MMC Office Building Initial Traffic Review Comments

Hi Nell – the following are initial traffic comments for the project for discussion purposes at tomorrow's meeting

**C30-01**

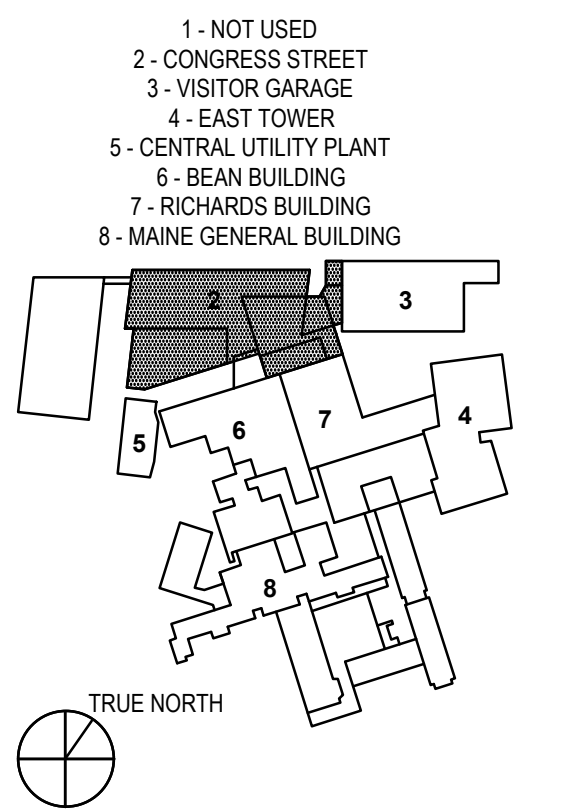
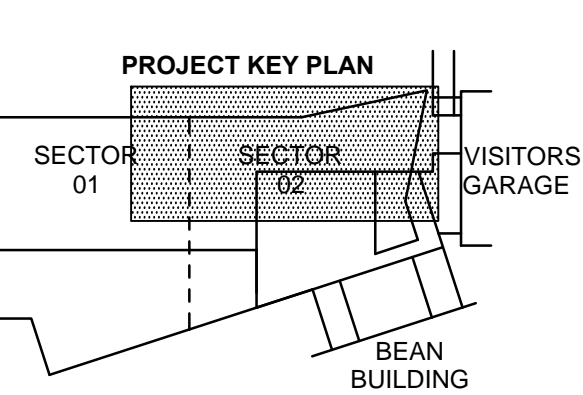
- The Gilman Street non-tangent curb alignment is not acceptable. A straight curb is suggested. Gilman Street width dimensions shall be provided.
- The flared curb ramp near the main entrance vehicle driveway is not acceptable partly because it creates a narrow pedestrian accessible route. Also, the crosswalk location should be evaluated.

- The provision of the City's preferred two ramp configuration at the Gilman Street corner should be investigated.
- Bus stop location and accessibility should be evaluated.

- Shuttle pick up and drop off operations at the employee entrance on Gilman Street should be detailed.
- Vehicle drop-off/pick-up operations/management at the vehicle loop should be provided.

- Pick-up/Drop-off loop interaction with parking garage entrance is a concern and an analysis should be provided.
- General sidewalk width given future pedestrian demand on Congress Street seems inadequate.

- Congress Street cross-section width should specifically be detailed. How will bikes, parking, bus, vehicles be accommodated
- Pedestrian movements across the parking garage entrance to the Main Entrance is a concern.

Truck route from construction site to 70 US Route 1. This route would be used primarily during the garage deconstruction phase of the project or whenever a left-turn onto Congress St is allowable given the size of the truck.

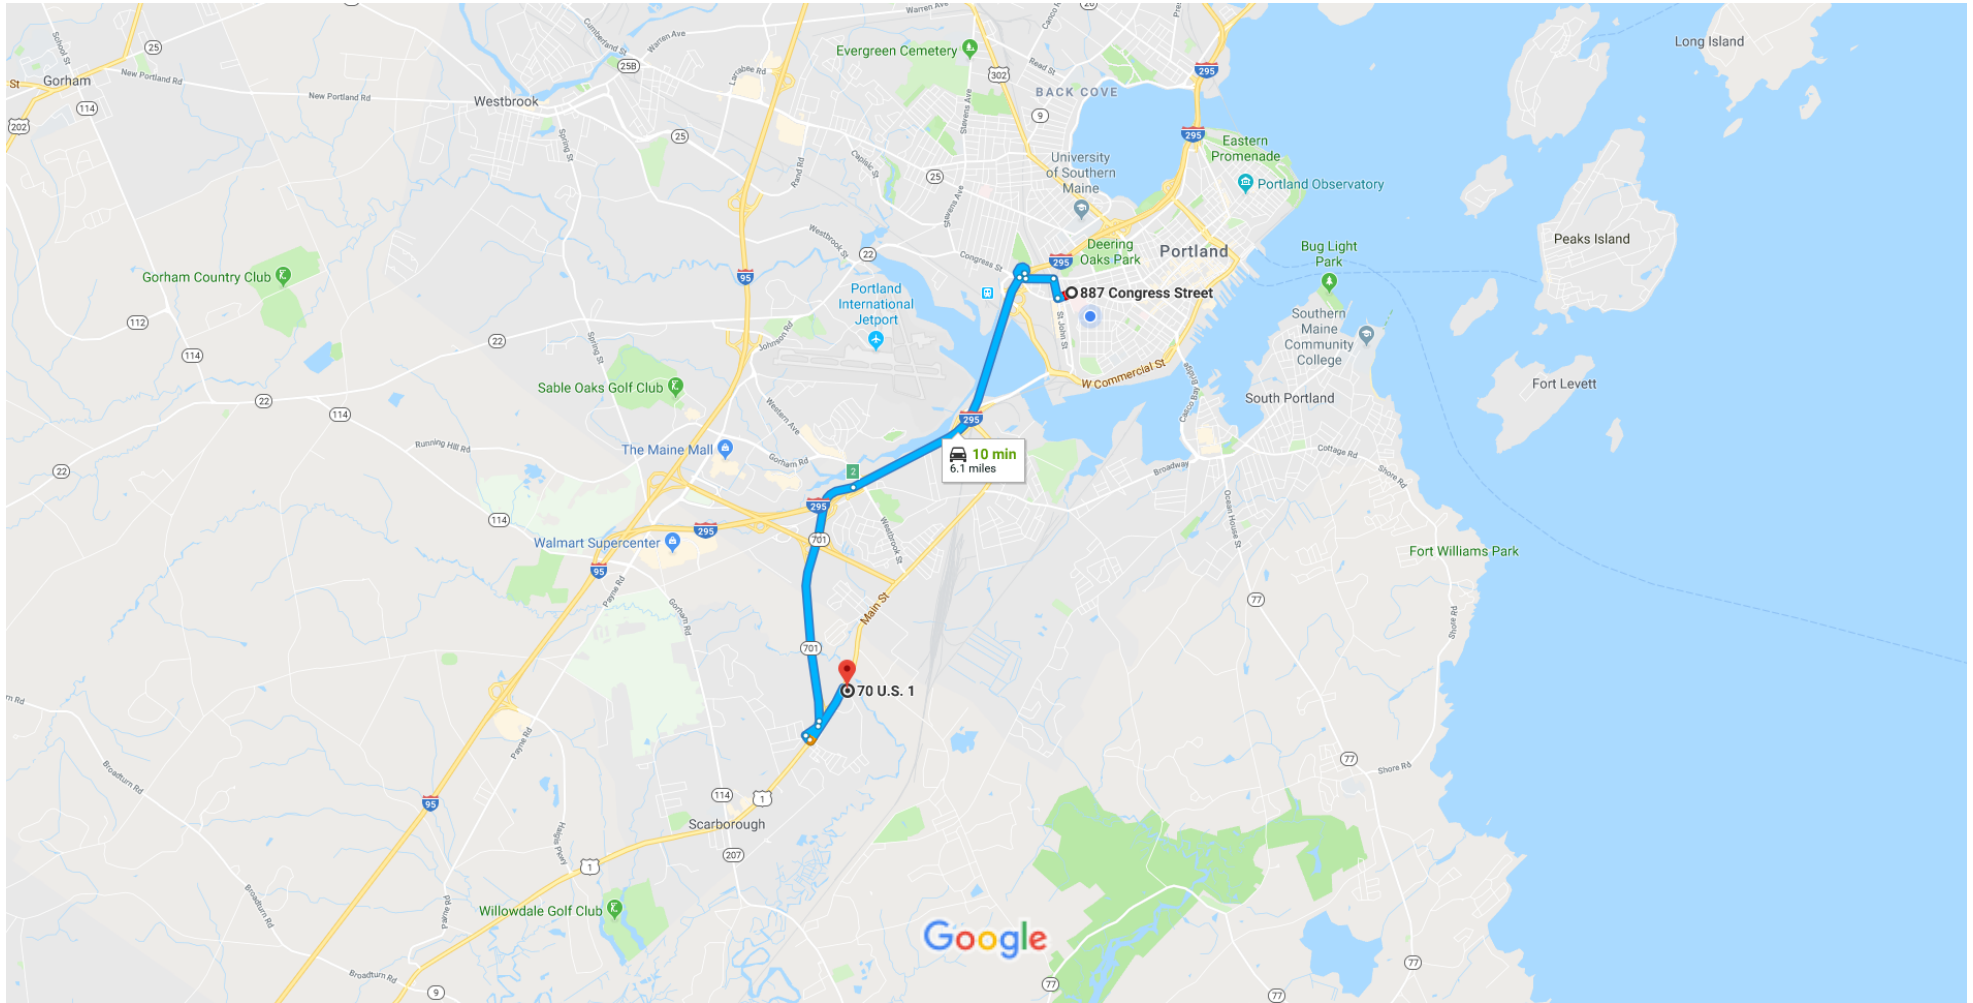
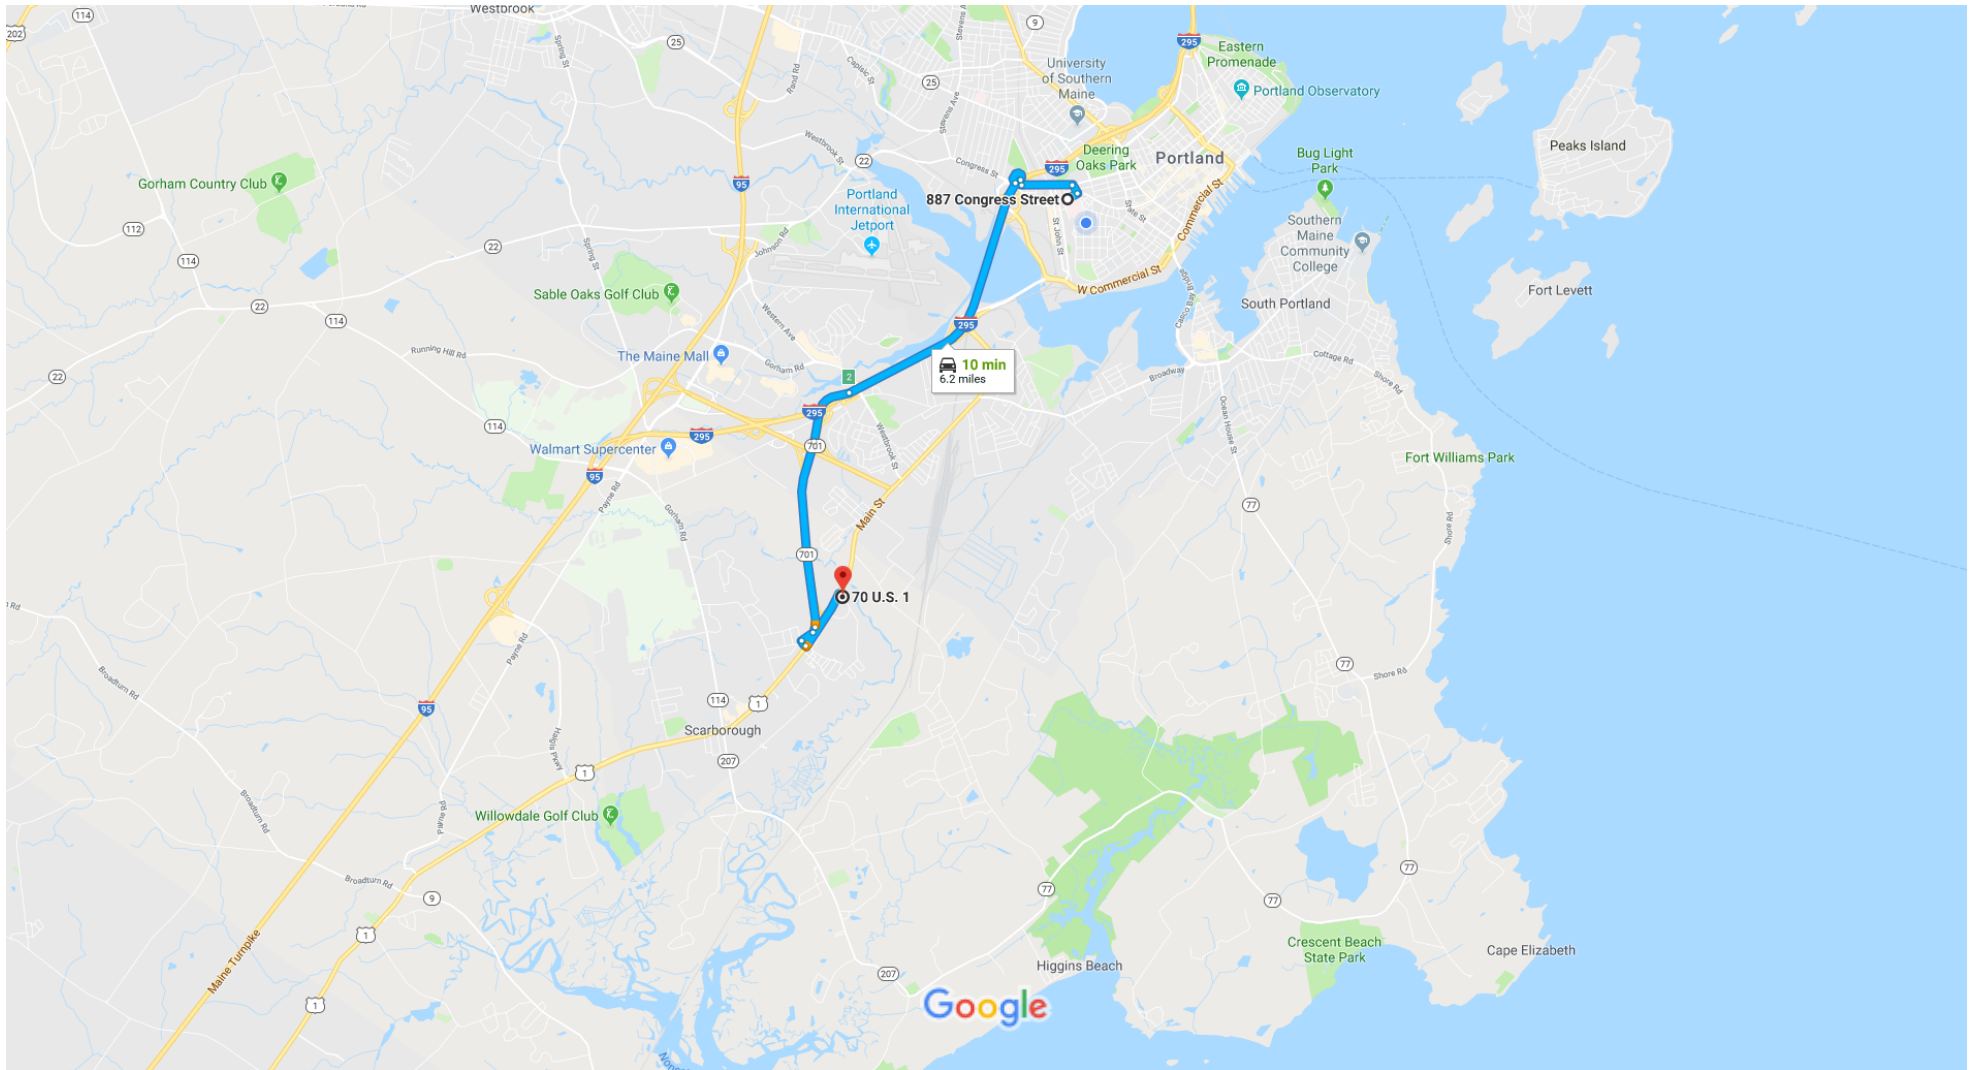
- Local truck routings should be clearly documented from each construction entrance.
 - Roadway widths shall be detailed.
 - Is a temporary protected sidewalk on Congress Street feasible (if not for the entire project – but during certain phases).

TITLE  
**SITE PLAN,  
GILMAN STREET,  
CONGRESS STREET  
EXPANSION**

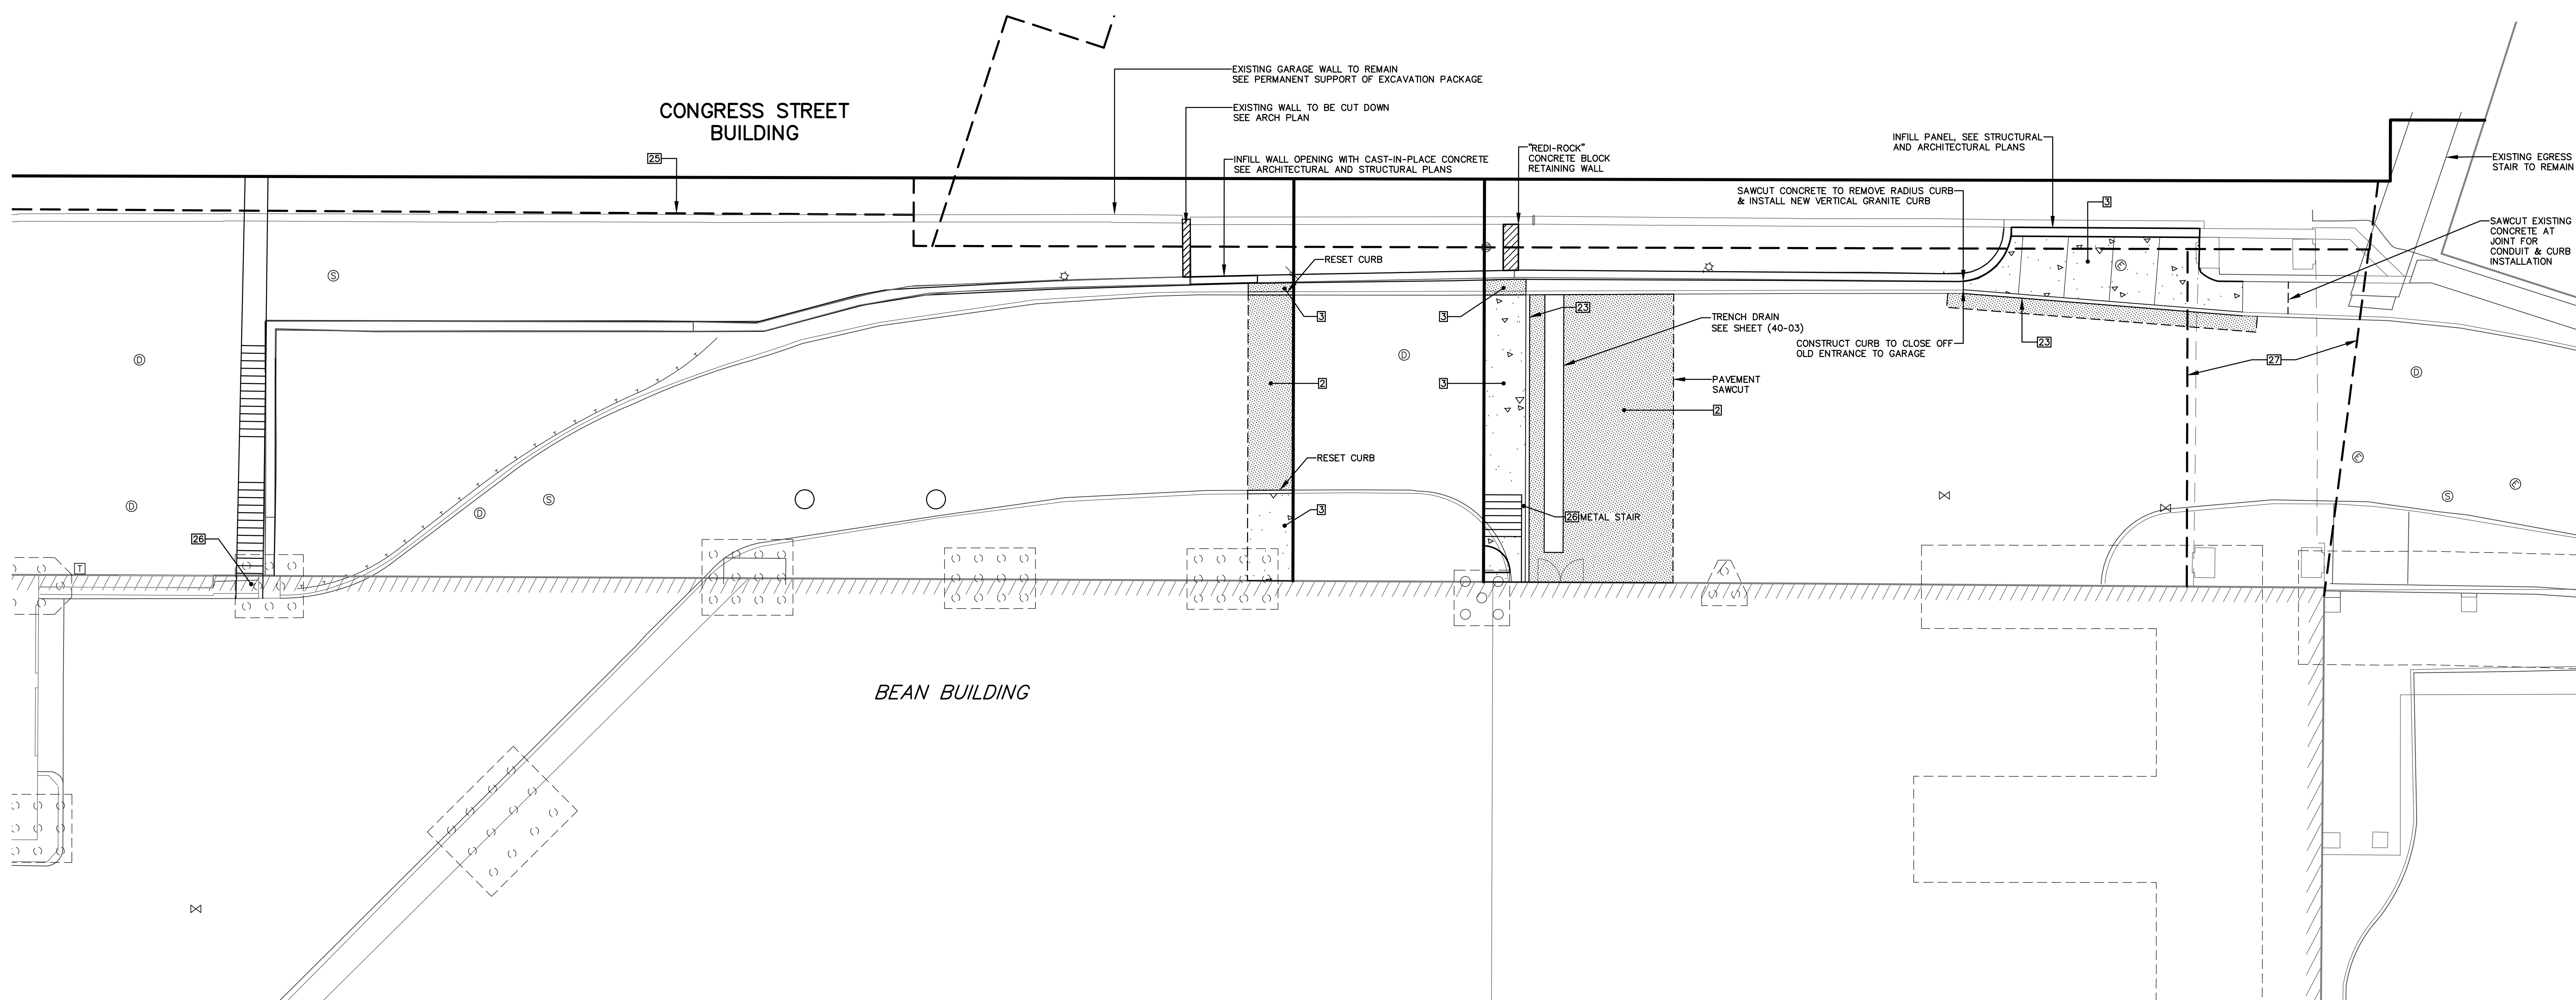
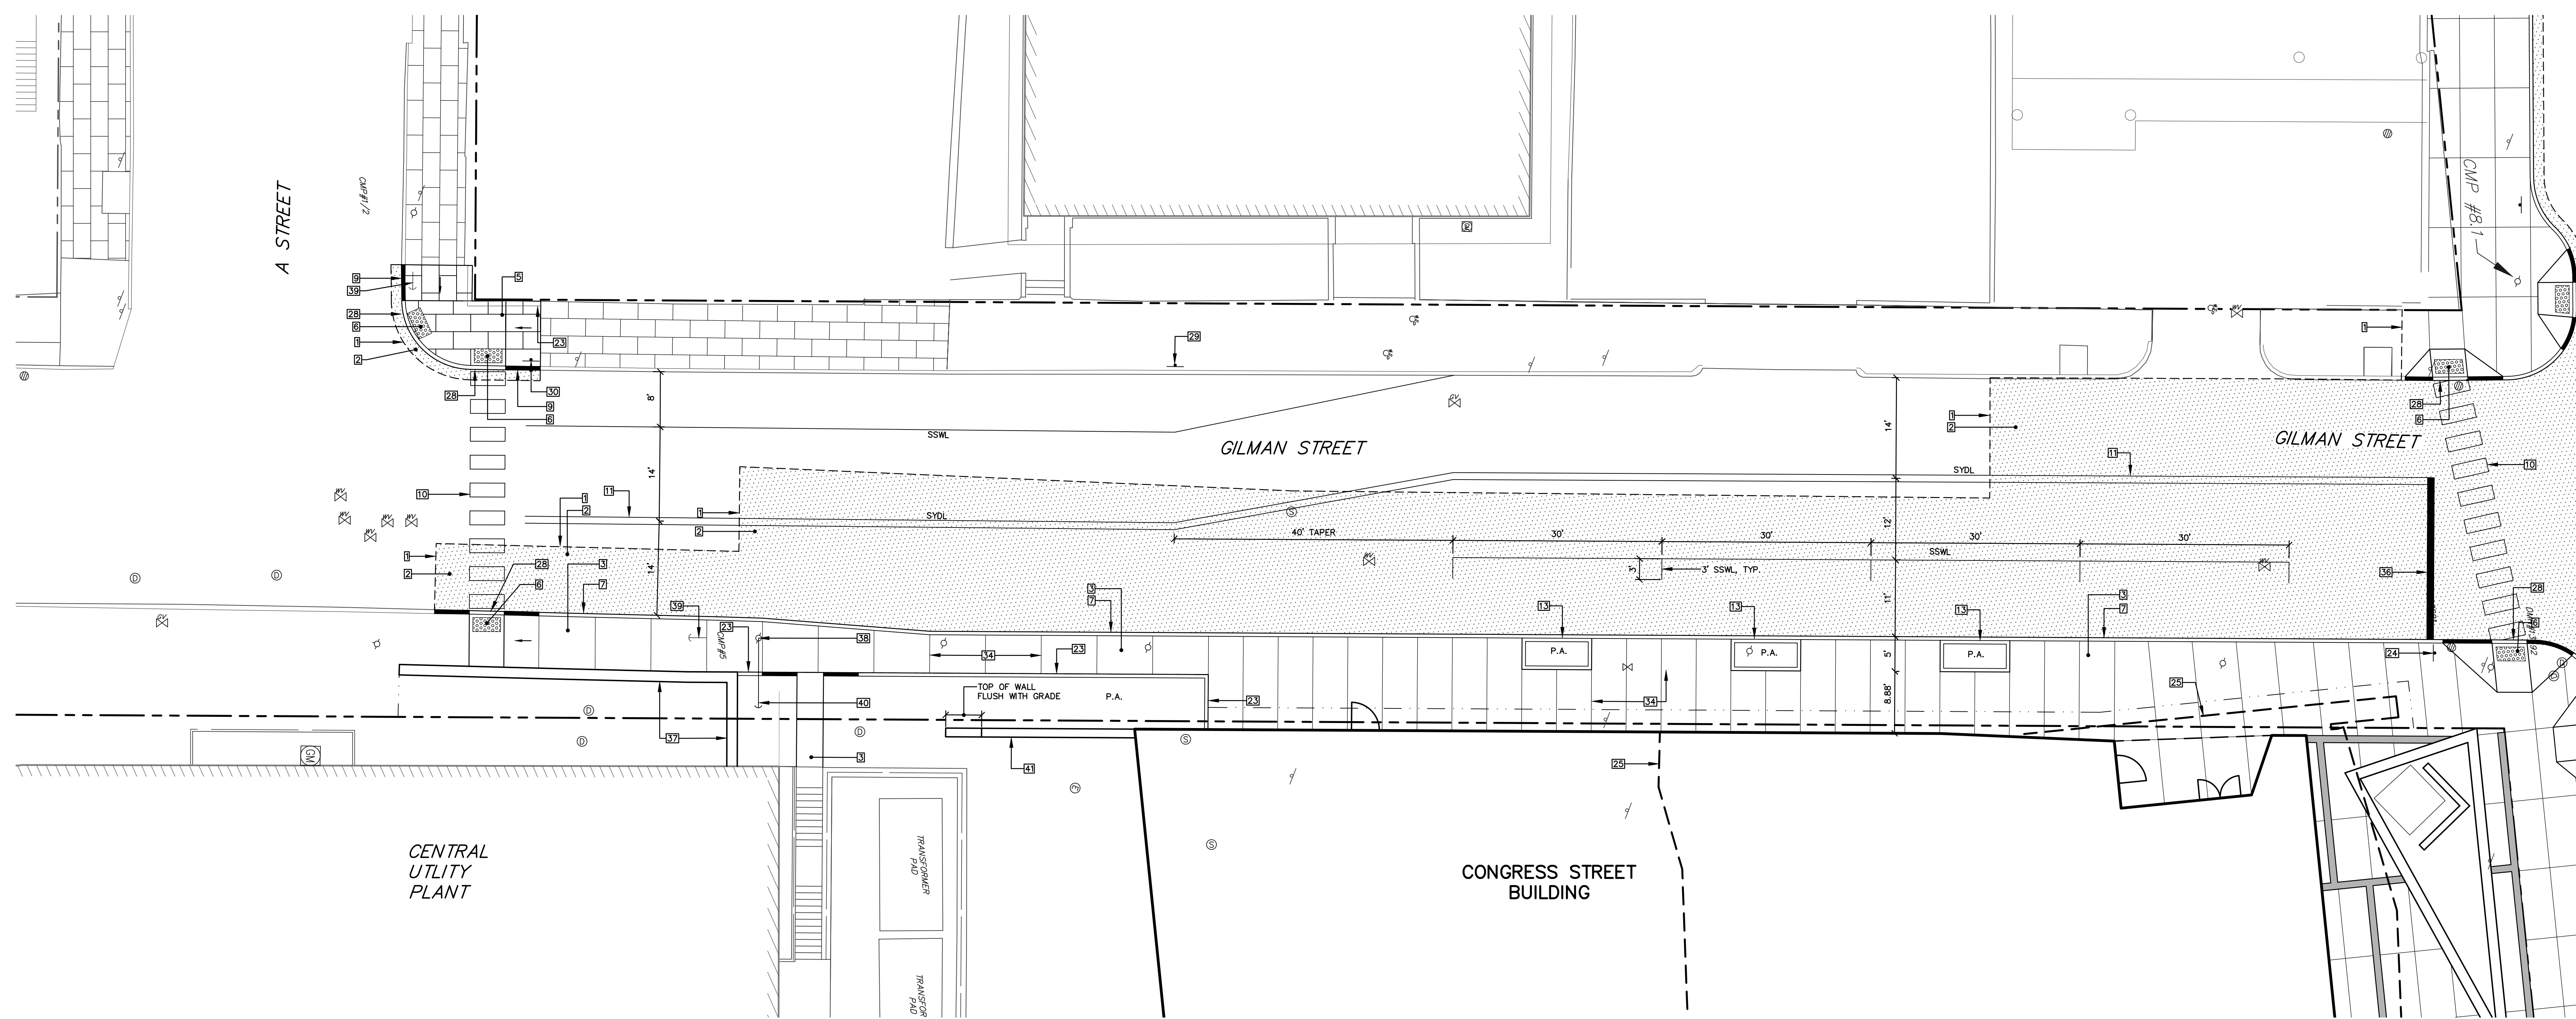
- A sidewalk on Gilman Street to A Street should be explored or a waiver analysis should be provided.
- I have briefly reviewed the Construction Management Plan and noted the following:
